Mountain View Electric Association, Inc. (MVEA) has these comments about the following:

Project Name: Cathedral Pines, Filing 6-Lot 1 & 2 Replat

Project Number: VR-17-004

Description: Approval is being requested for the vacation and replat of the common lot line between Lot 1 and 2 of Cathedral Pines, Filing #6. The address of these properties is 4090 and 4120 Foxchase Way in Section 02, Township 12 South, Range 66 West.

CP-FILE REPLAT.DWG
MAY 5, 2017
PROJECT 17036
SHEET 2 OF 2

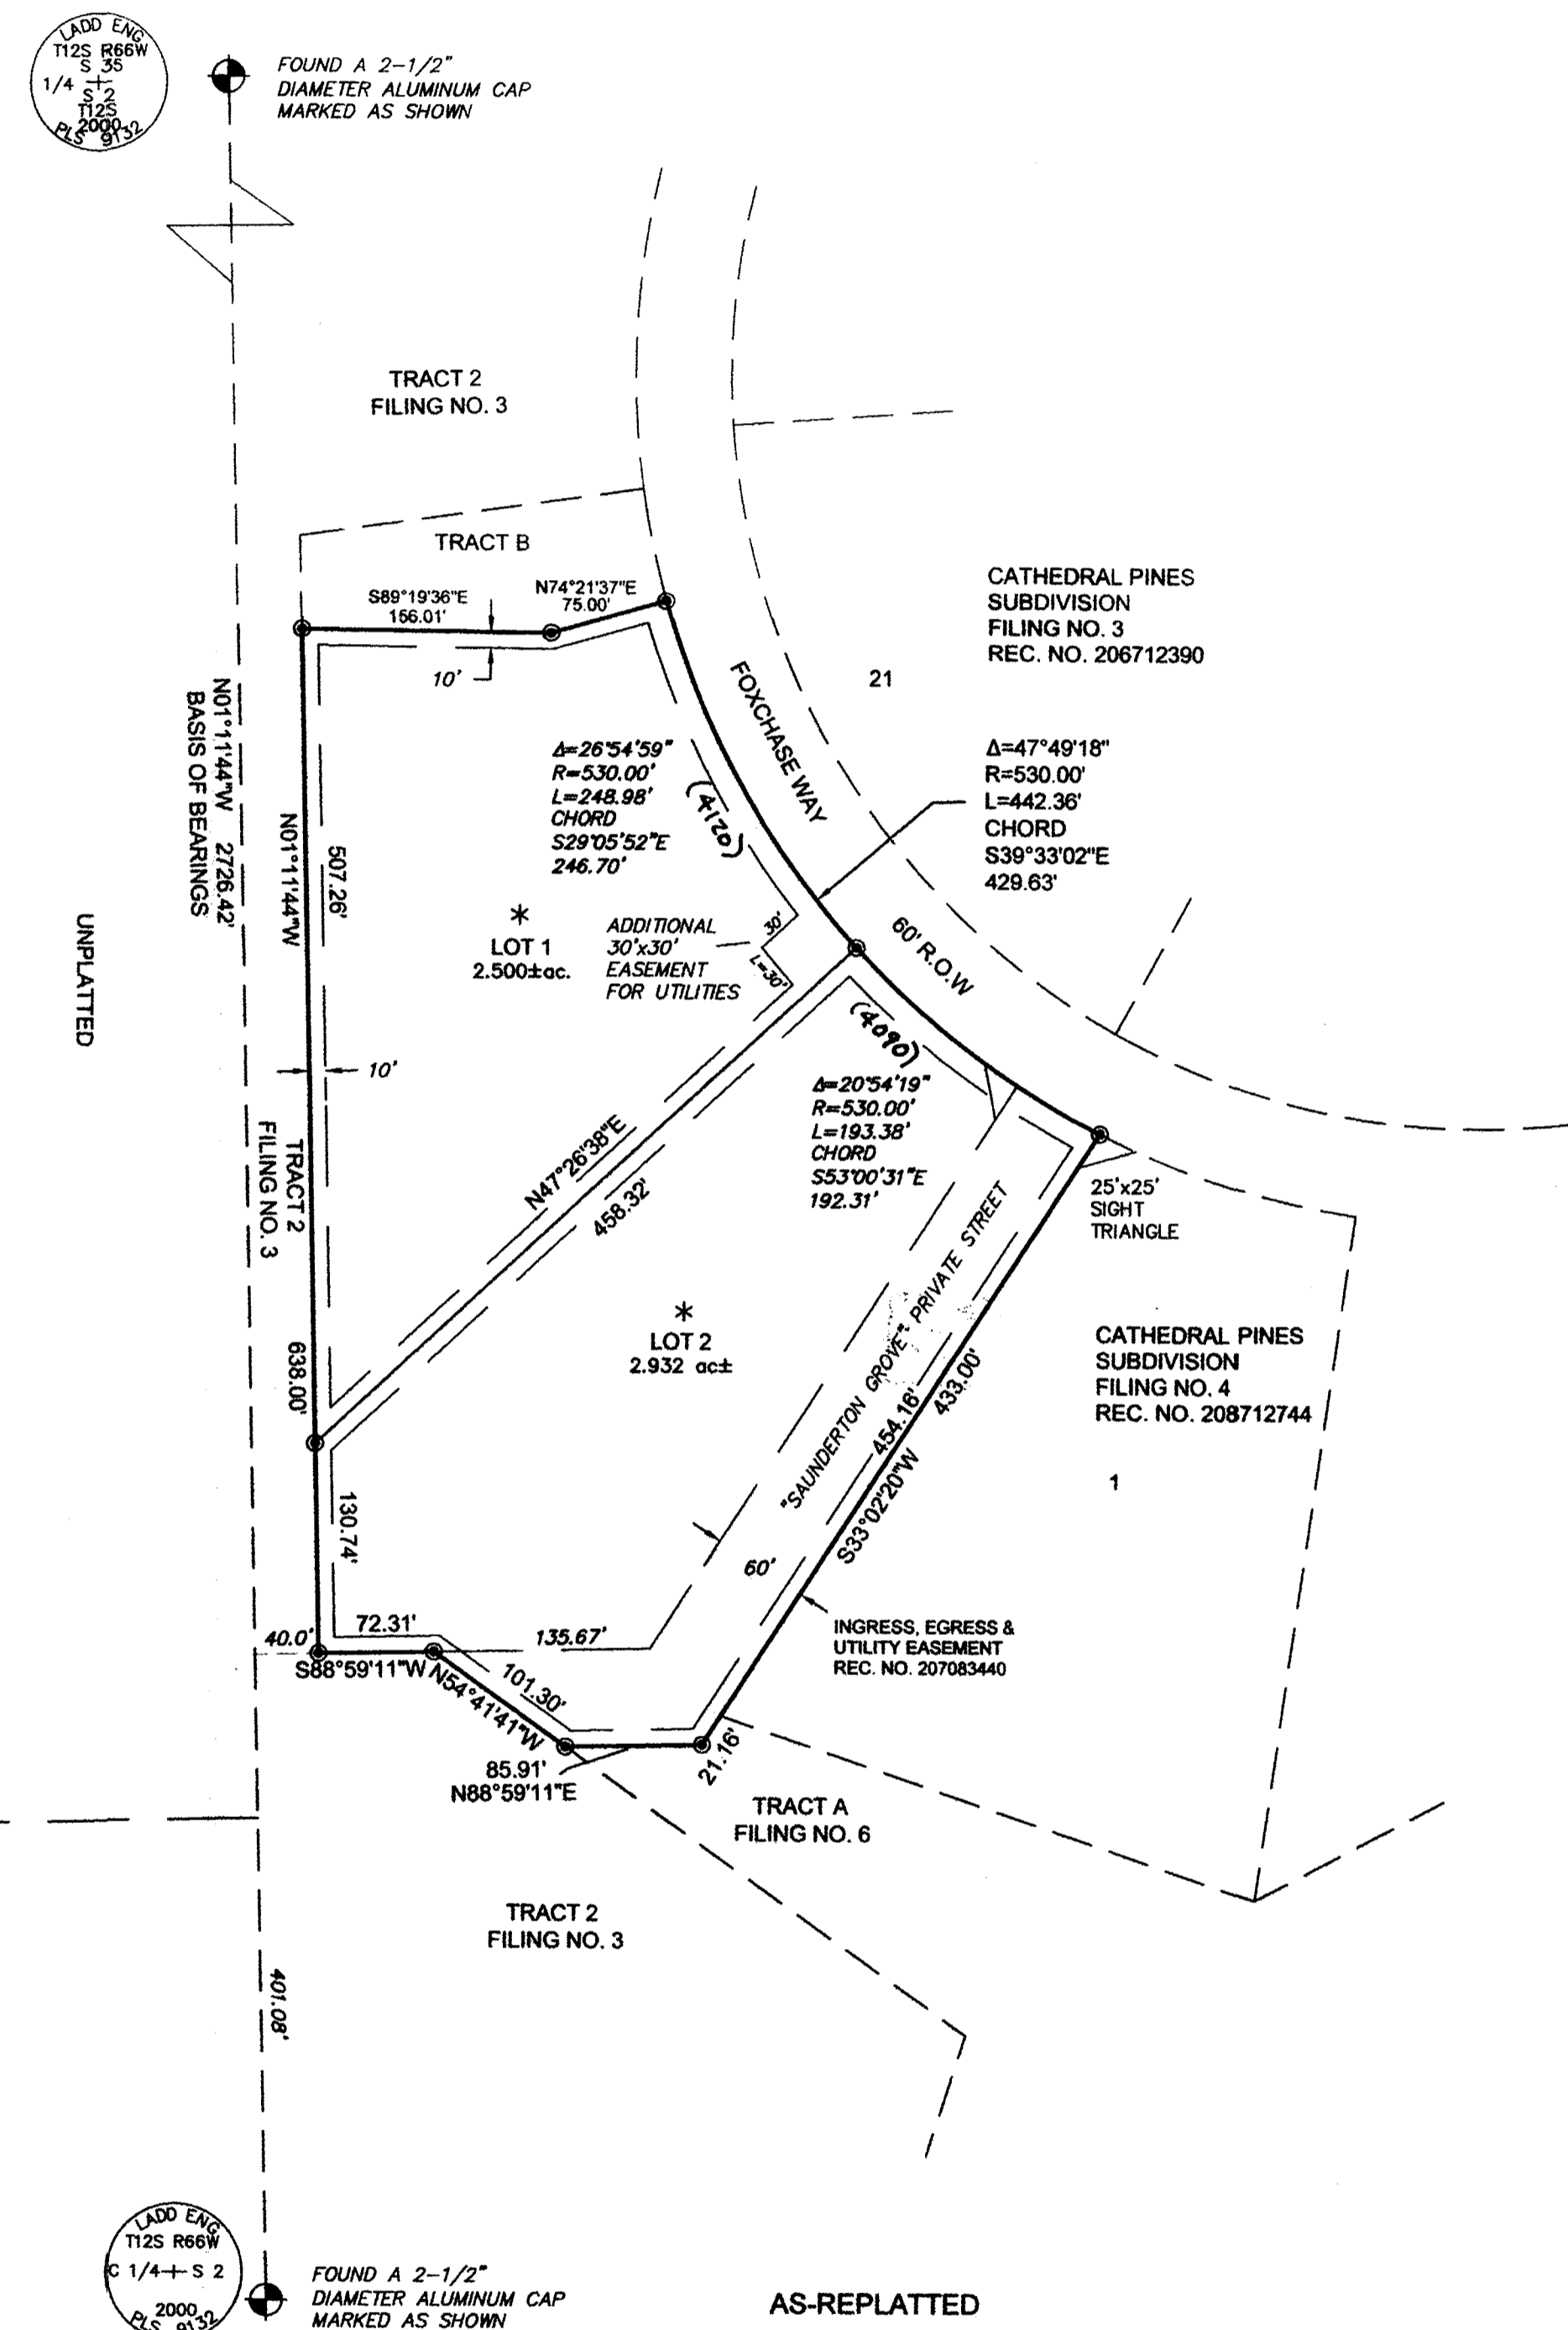
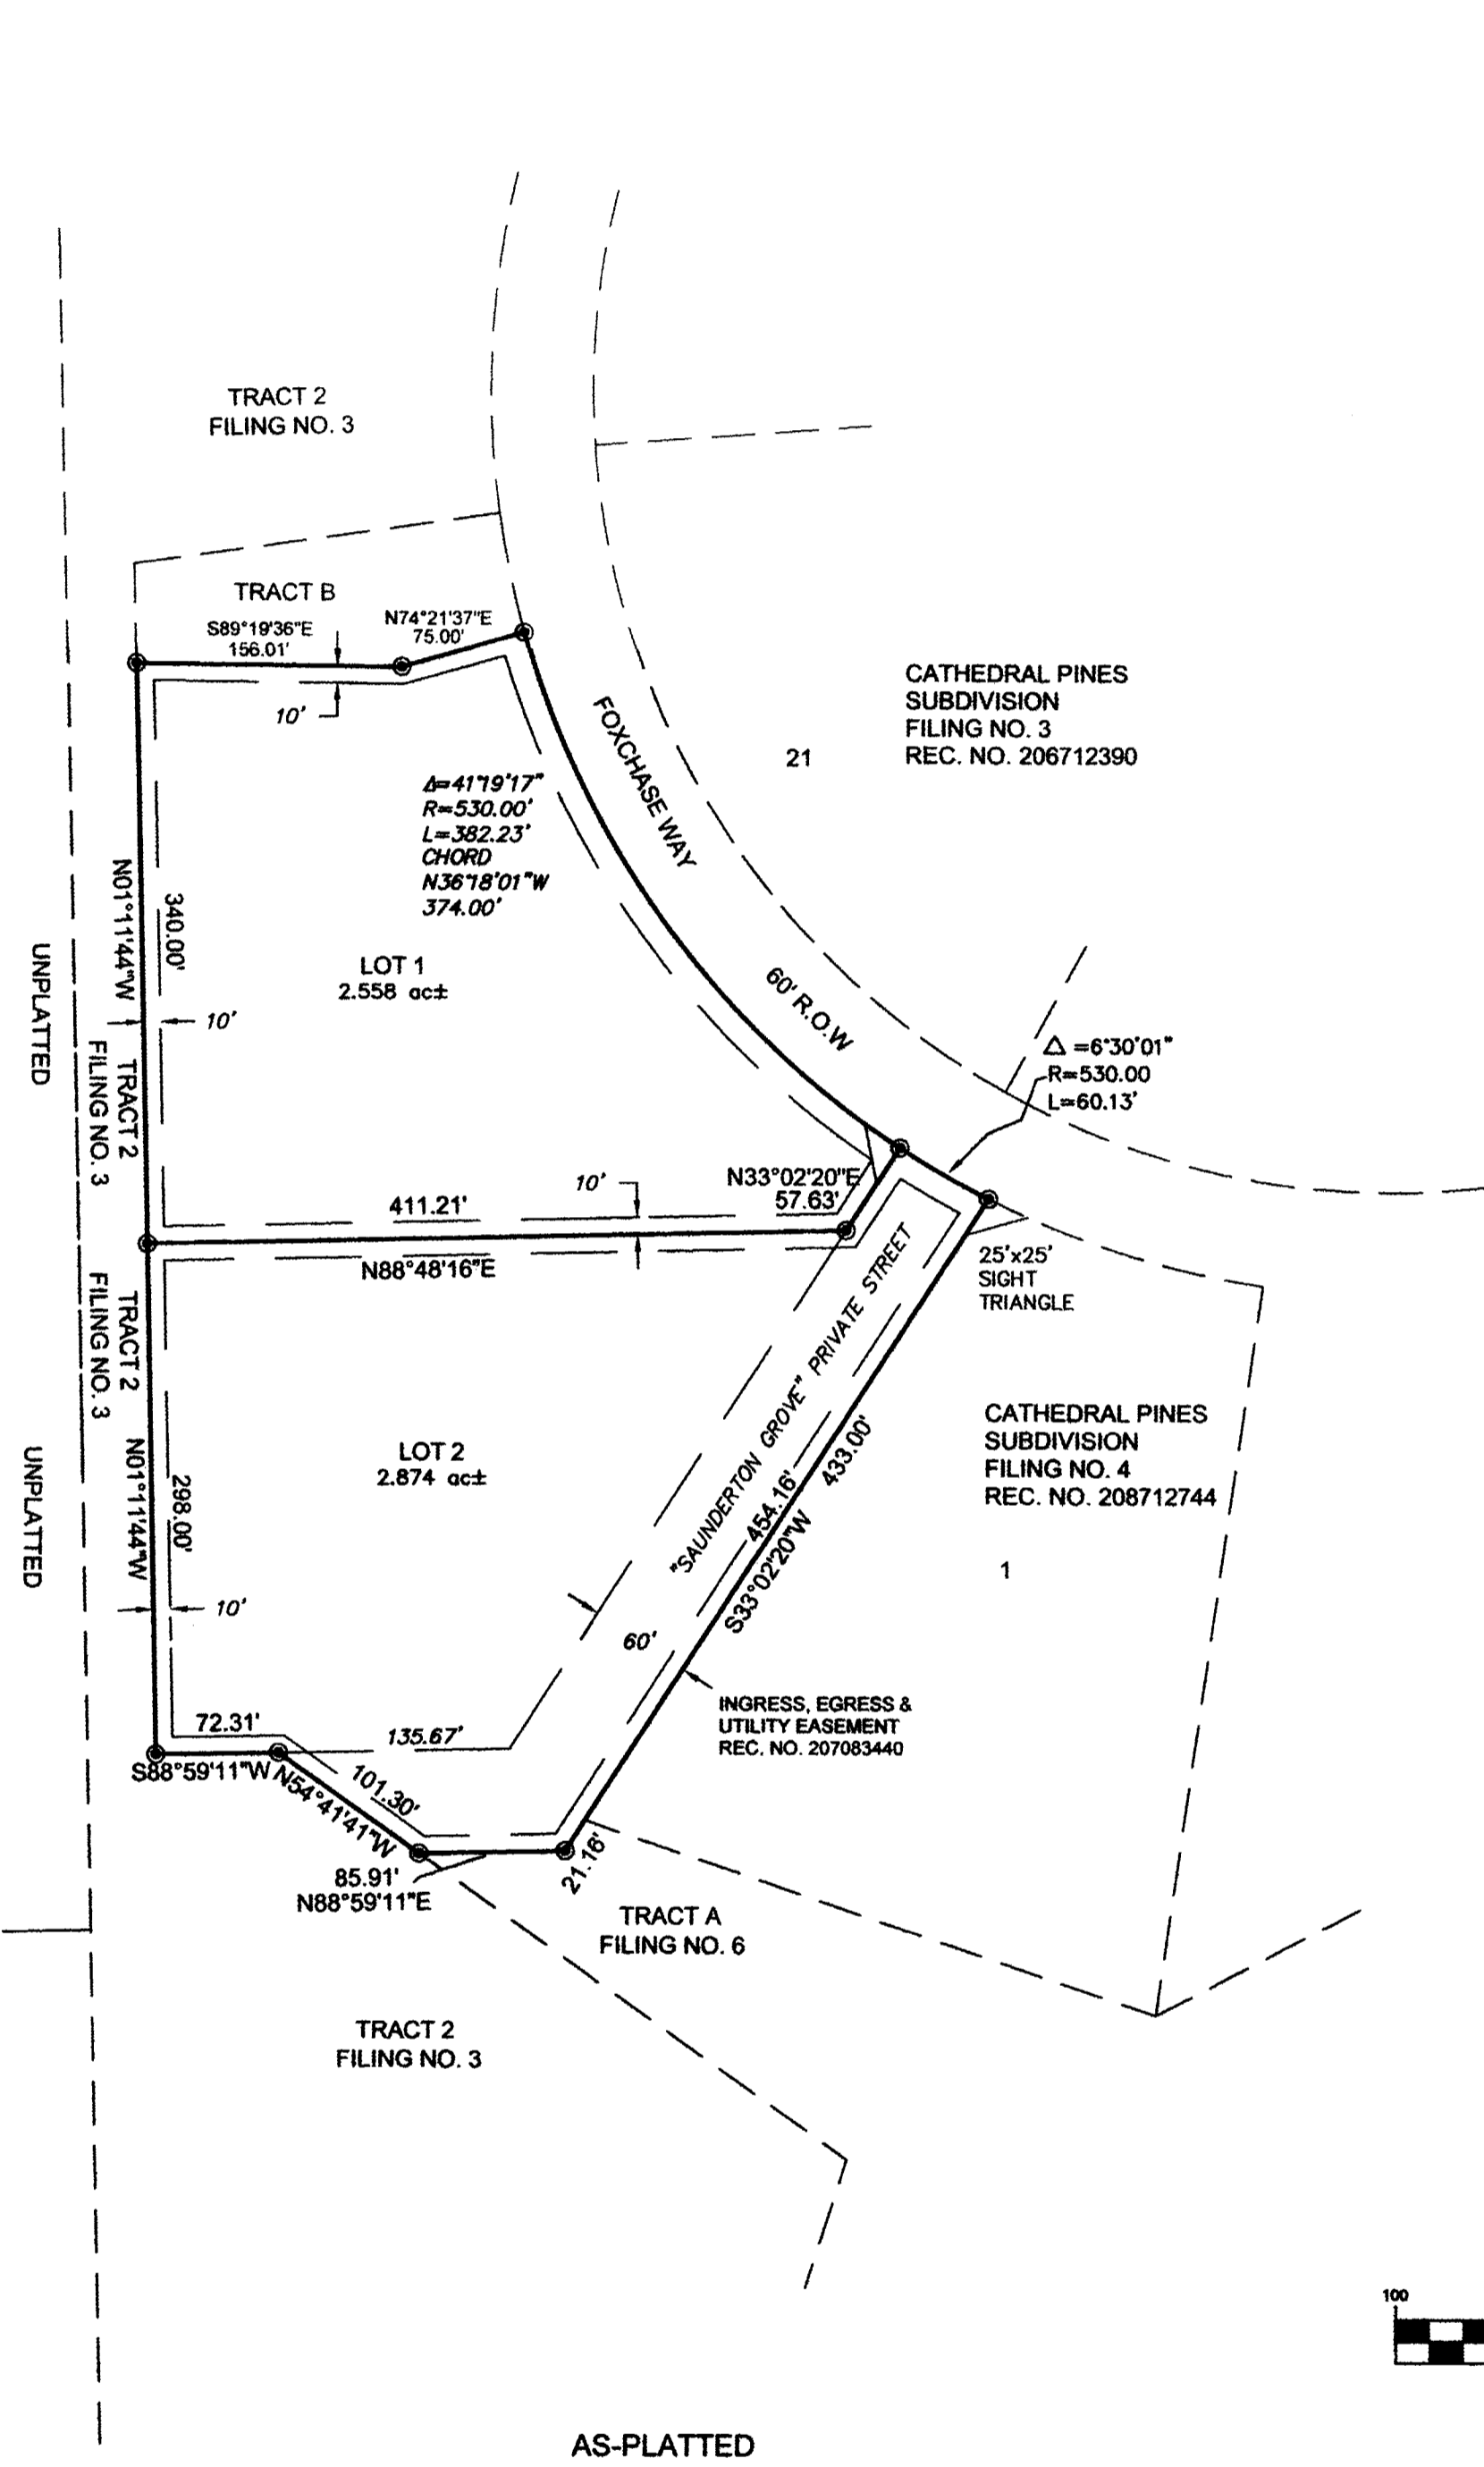
MVEA requests the platting of the utility easements shown on the Final Plat of Cathedral Pines, Filing #6 of fifteen (15) foot front lot utility easement and ten (10) foot side and rear lot line utility easement. Also, please show the existing MVEA facilities with easement on the plat.
